30 November 2020

2190947

Response to Further Agency and Organisation Submissions Powerhouse Parramatta – SSD 10416

Post-development - River Flood  
No Grill & Open Undercroft vs Baseline Conditions  
Afflux  
1% AEP (540 min)

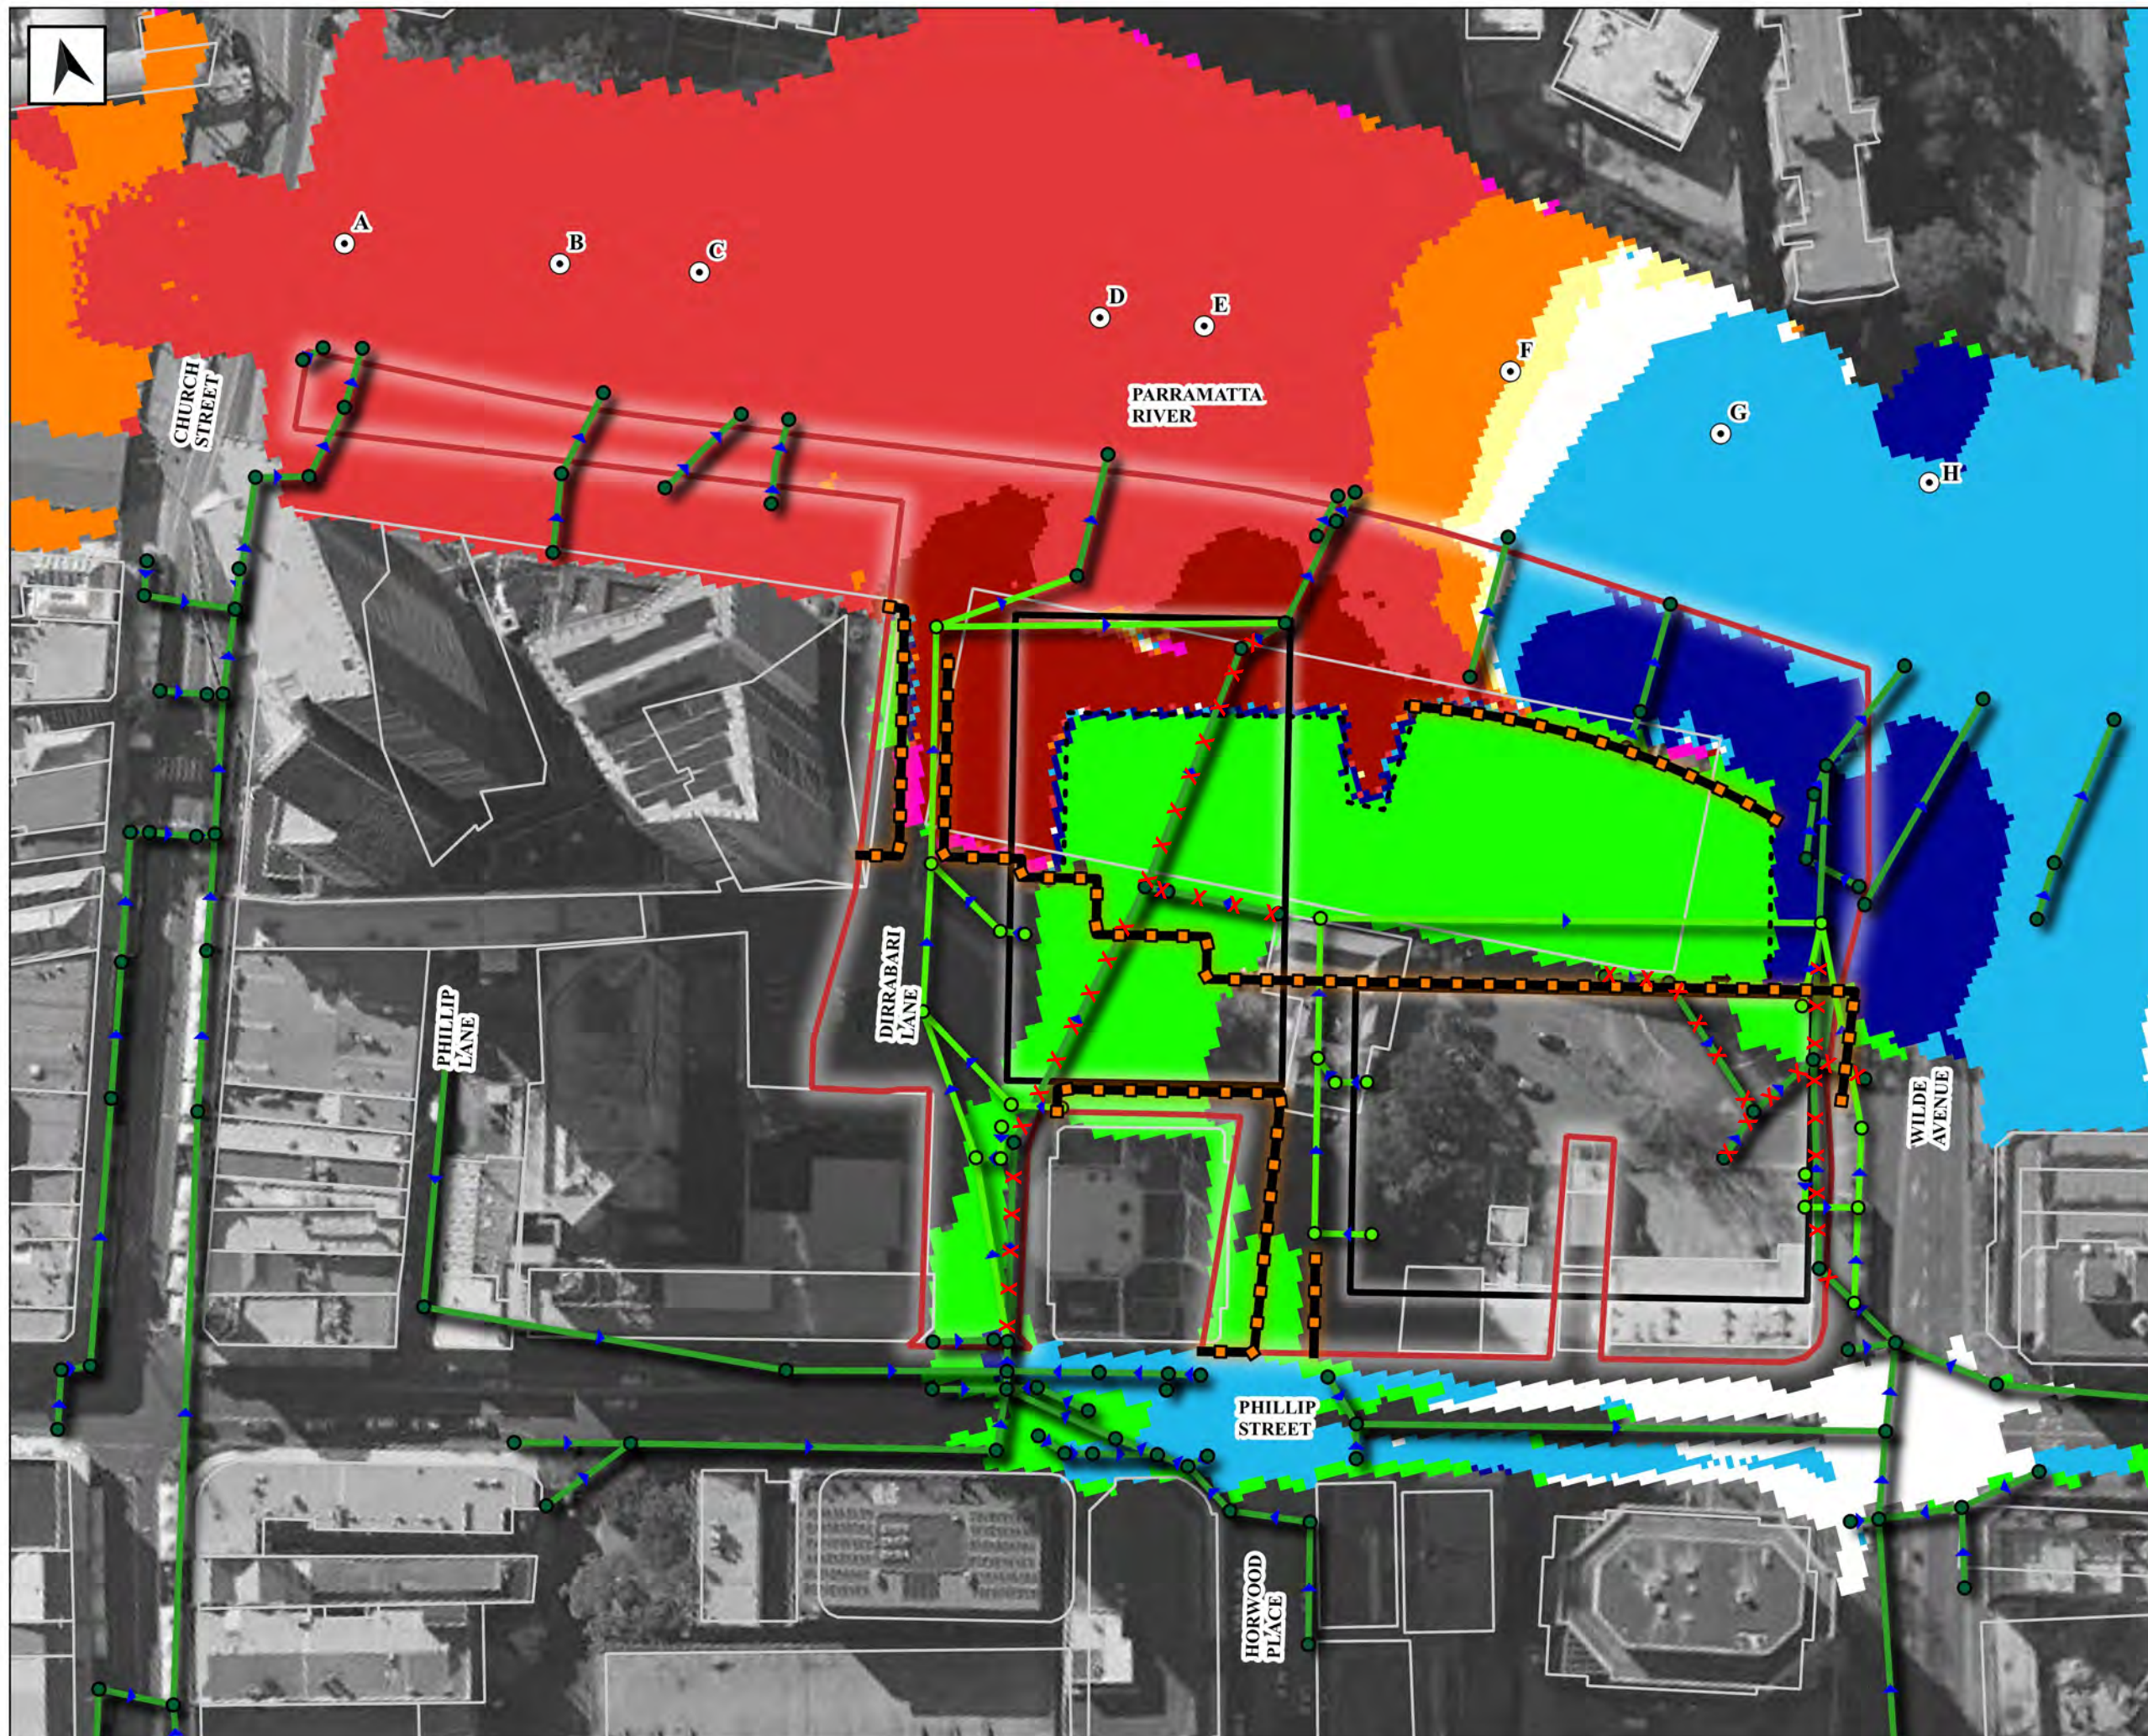
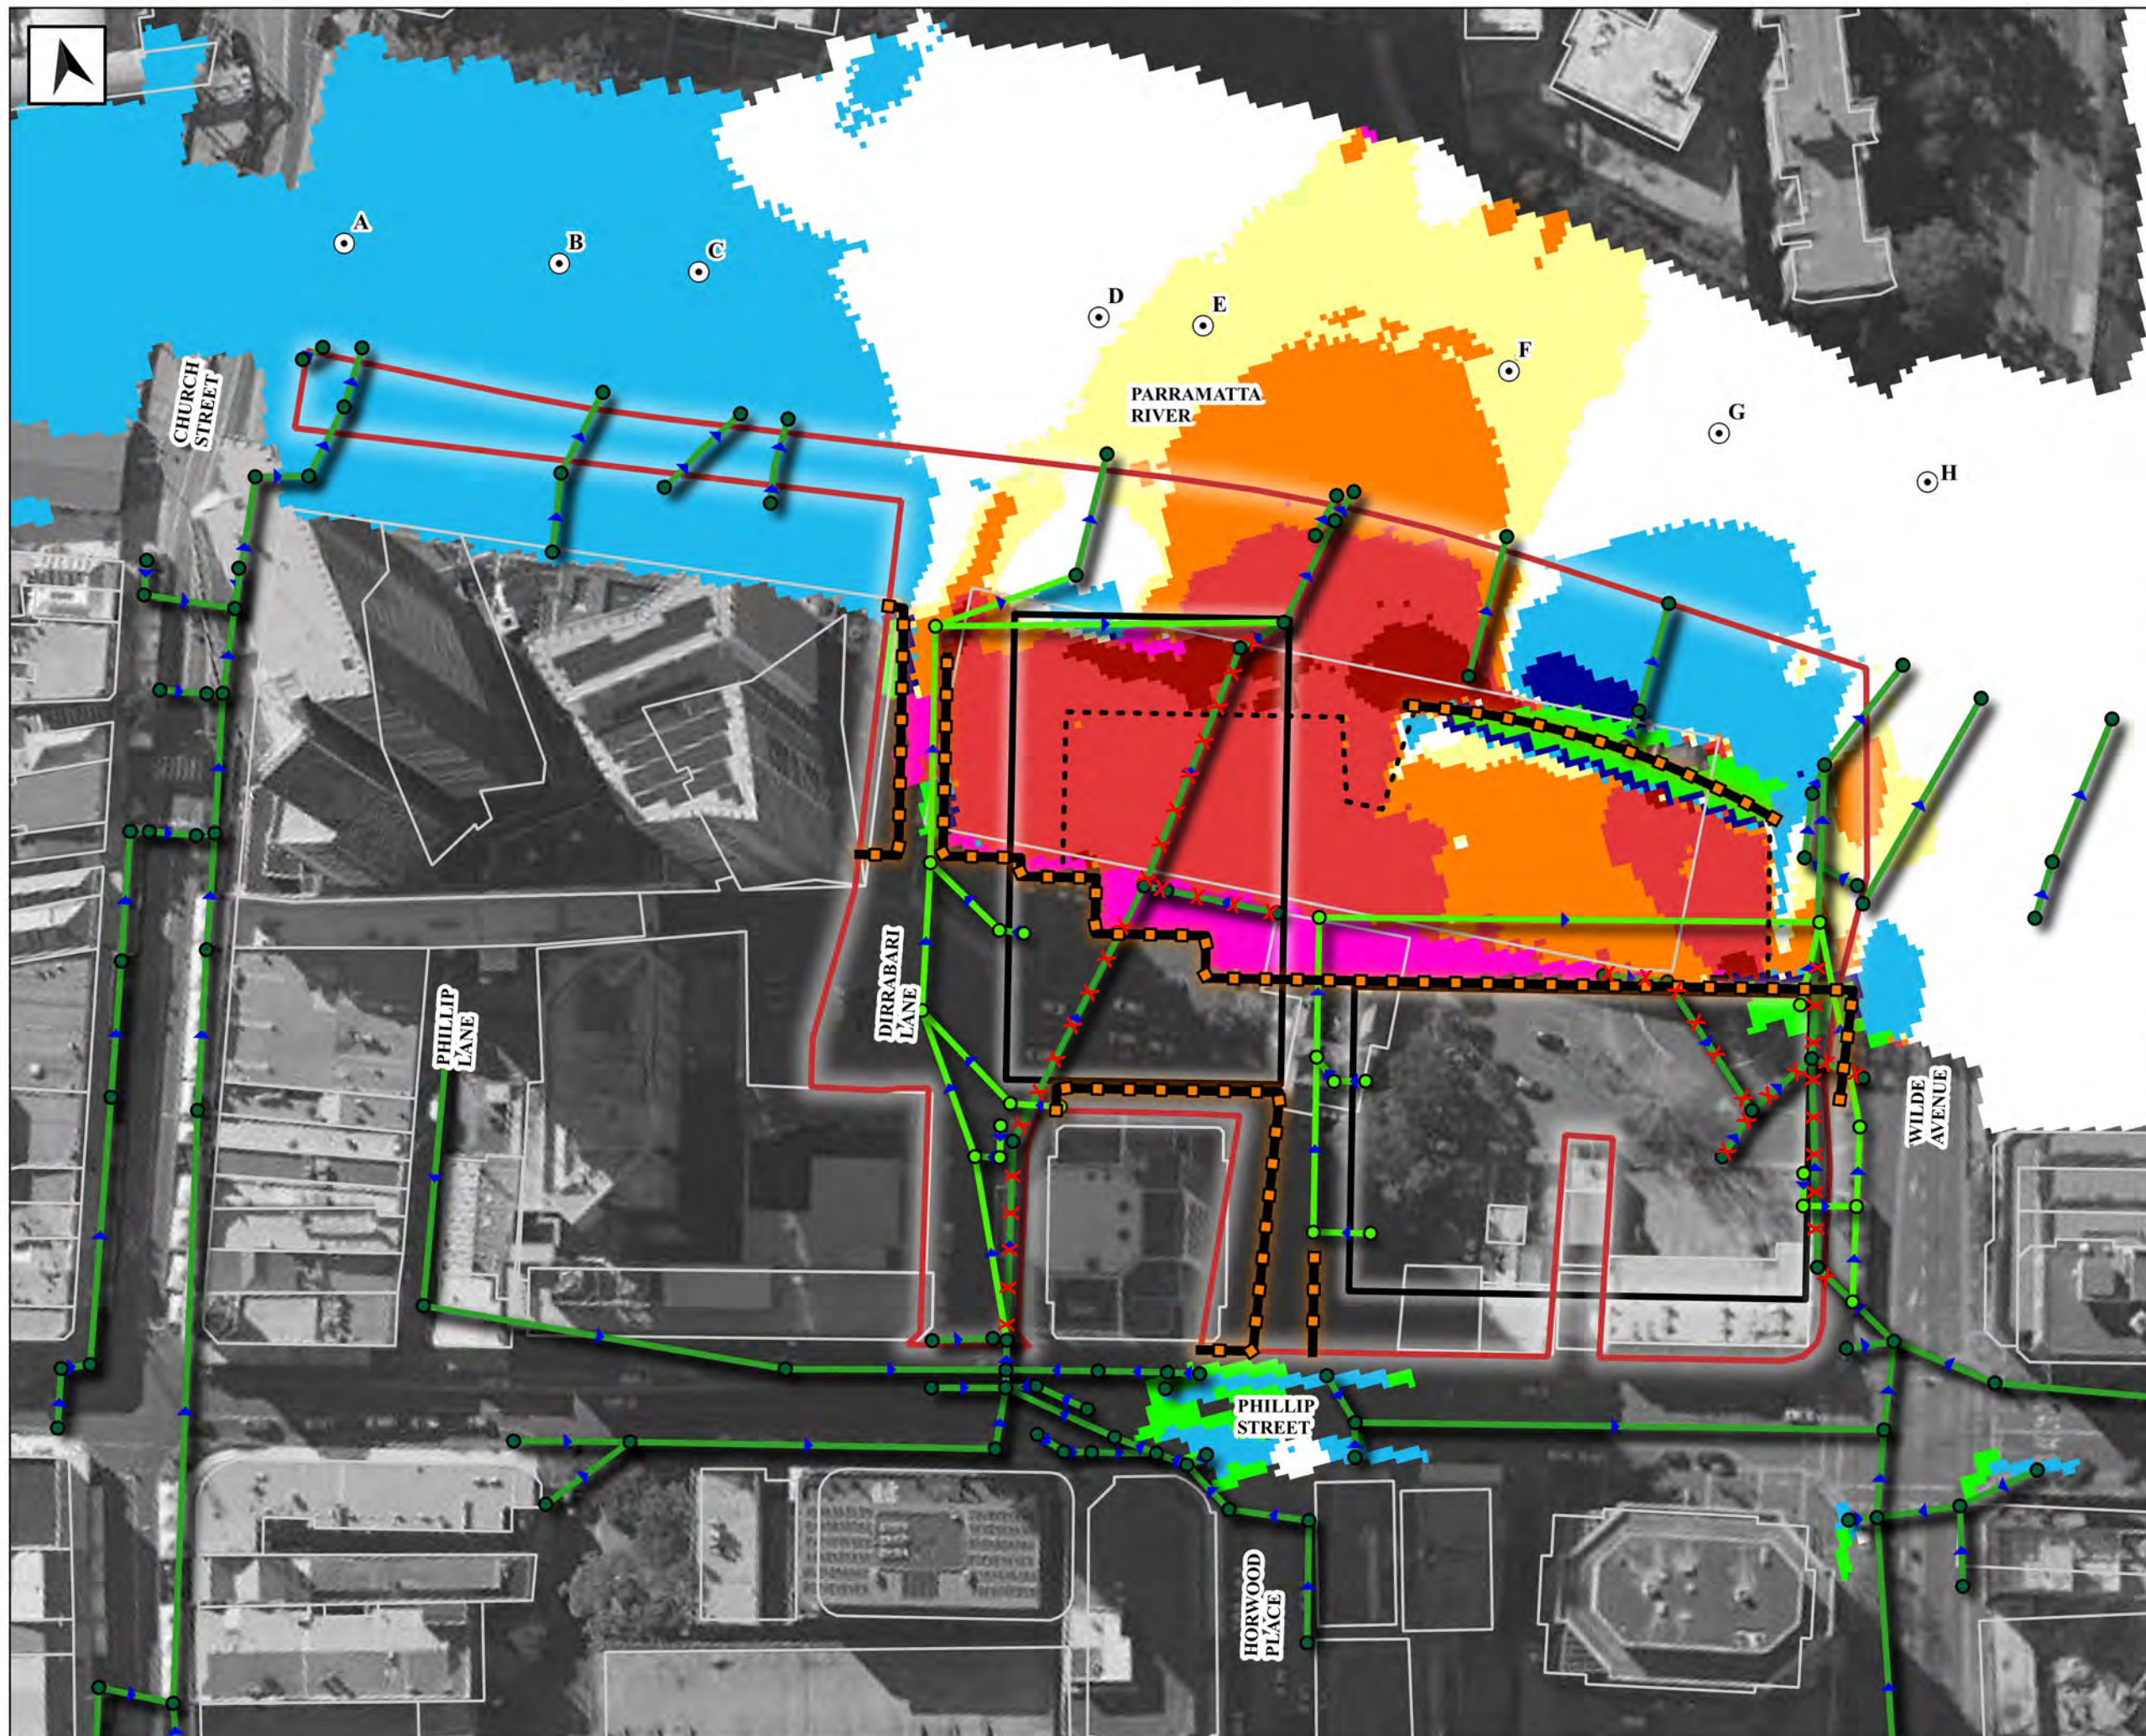
No.	Extract	Comment
CoP1	<p>Flooding and the Undercroft</p> <p>Council recognises the efforts made to modify the design to align with the Competition winning visualisation that showed a landscape solution that included a sloping embankment and a seamless relationship with the Parramatta River. Notwithstanding, the reality of the design is that the undercroft remains and the embankment serves to obscure it. The primary purpose of the undercroft is to convey floodwaters and at the same time provide additional habitable floor space for use by the Museum. Council maintains its view that the undercroft is not an appropriate solution for the site.</p> <p>In the Response to Submissions Report prepared by Ethos Urban on behalf of Infrastructure NSW dated 8 October 2020, it states that in response to concerns raised during the exhibition period, further detailed flood modelling was undertaken which confirmed that 'the proposed undercroft area is the best and only outcome for the site to mitigate and appropriately manage riverine flooding'. Council is contrary to this view.</p> <p>While Council acknowledges that the undercroft space will have limited access by the public through the erection of moveable screens managed by the Powerhouse, Council maintains its concerns regarding the suitability of the undercroft as a flood solution where the conveyance of floodwater through the undercroft also passes through proposed habitable floor space. This is due to the potential threat to life, property and critical building services in a flood event (including evacuation via a single, limited capacity lift, which provides critical access to mobility impaired). Council considers this to be in contradiction of the</p>	<p>As outlined in the Response to Submissions and accompanying Flood Risk and Stormwater Management Addendum Report, the Applicant maintains that there is no alternative to the inclusion of the undercroft whilst maintaining the architectural design of the museum. Adjustments have been made to the undercroft, in particular in relation to its use and management in response to Council's concerns, however, it is noted that contrary to this submission the undercroft is not considered to be habitable floor space. Flood modelling and advice confirms that the undercroft is a suitable flooding response.</p> <p>The Applicant maintains that the design and operation of the undercroft as well as the broader Powerhouse Parramatta proposal remains appropriate and safe from a flooding perspective. The concerns identified in Council's submission have been previously addressed in detail in the Response to Submissions and accompanying Flood Risk and Stormwater Management Addendum Report, and the responses in these documents should be referred to.</p>

No.	Extract	Comment
	<p>Floodplain Development Manual and NSW Flood Policy. This space will have a level floor and the 1% AEP (100 year) floodwaters will flow with substantial velocity 2-3m deep extending to the back wall of this structure.</p> <p>It is Council's view that there are alternative solutions, including a design that delivers an alternative means of achieving floodwater conveyance along the river through an appropriately designed landscaped riverbank. There are other reaches of the river nearby with similar river flow, river width and which have cross sections that contain this 1% (100 year) flow within the boundaries. These typically have sloping banks that enable people to safely find their way to higher ground out of the river corridor as floodwaters rise.</p> <p>In this regard, Council reiterates its earlier recommendation that the undercroft be removed from the design. It also recommends the undercroft be replaced with a suitable sloping riverbank section that may be a viable solution to manage the conveyance of floodwater. This would also have the added benefit of creating a more integrated foreshore landscape interface where the 'natural' sloping riverbank profiles that existed before the existing car park was originally constructed (and which appear to be still visible on site) could be considered as the baseline for predevelopment conveyance capacity and afflux considerations.</p> <p>In relation to overland flow, once riverine flooding and conveyance has been resolved safely - by changing the built form and surrounding landform, it will also be necessary to re-examine the overland flow pathways across the site and how these affect useability, public safety and risk management.</p>

AU3	<p>Following review of the RTS, Australian Unity remain concerned regarding the overland flooding considerations.</p> <p>The existing 600mm diameter pipe which currently runs under Dirribarri Lane and the multideck carpark will be replaced by a 1200mm diameter pipe running under Dirribarri Lane and heading directly north to the river. On the eastern side</p>	<p>It is noted that the advice provided by Molino Stewart is not made in relation to the documentation provided with the Response to Submissions. The matters raised within this submission are adequately dealt with in Appendix J of the Response to Submissions Report.</p>

No.	Extract	Comment
	<p>of the subject site a new 600mm pipe will be laid to take water directly to the river between the two museum buildings.</p> <p>Molino Stewart have raised concerns with the flood modelling prepared by Arup at Appendix O of the EIS. In particular, concerns are raised in relation to whether adequate consideration has been given to the potential blockage of stormwater pits. Blockage in stormwater pits has the potential to change the reported flood modelling results.</p> <p>It is noted that City of Parramatta Council requires an assumption of a 100% blockage factor for any flood modelling associated with development applications in the CBD. This assumed blockage percentage will have a significant bearing on whether the proposed development will increase or decrease flood levels at the subject site.</p> <p>The existing stormwater flows pond in front of the subject site and flow in a 600mm diameter pipe under the Dirrabirri Lane to the river. When the flows to the low point exceed the capacity of the pipe the water rises until it reaches the high point in Dirrabirri Lane and the high point in Willow Grove and flows overland around the subject site.</p> <p>If the inlet to the 600mm diameter pipe is partially blocked, less water will get into the pipe and more water will have to flow overland to the river in the same storm event. This means that any blockage in the pipe will increase the depth of the flows around the subject site and the depth of ponding in front of the building. A 100% blockage will mean all the flows go overland and maximise the flood depths at the subject site.</p> <p>The overland flow management strategy for the PPM is to increase the capacity of the pipe in Dirrabirri Lane and to provide a new pipe to take overland flows along the eastern side of the subject site. This will effectively increase the flow rate underground and reduce the flow rate overland. Molino Stewart are concerned that if the inlets to the pipes are 100% blocked then they will make no contribution to flood conveyance and will not reduce flood levels at the subject site. As it is proposed to increase the ground levels to the east of the subject site and if Dirrabirri Lane is increased in level, then overland flow water will need to pond to a higher level in Phillip Street and increase the flood levels for the subject site.</p> <p>Requested Actions:</p> <p>3a) Australia Unity support the provision of amplified stormwater pipes on either side of 32 Phillip Street site.</p> <p>3b) The flood impacts of the final PPM design should be tested using City of Parramatta Council's more up to date, and peer reviewed, flood model when it becomes available to ensure that there will be no adverse flood impacts on the subject site or the surrounding public domain.</p>

No.	Extract	Comment
	<p>3c) The PPM project team should be requested to provide updated flood modelling accounting for an appropriate blockage percentage for stormwater pits.</p> <p>3d) The civil design solution must not increase flood levels adjacent to 32 Phillip Street.</p>
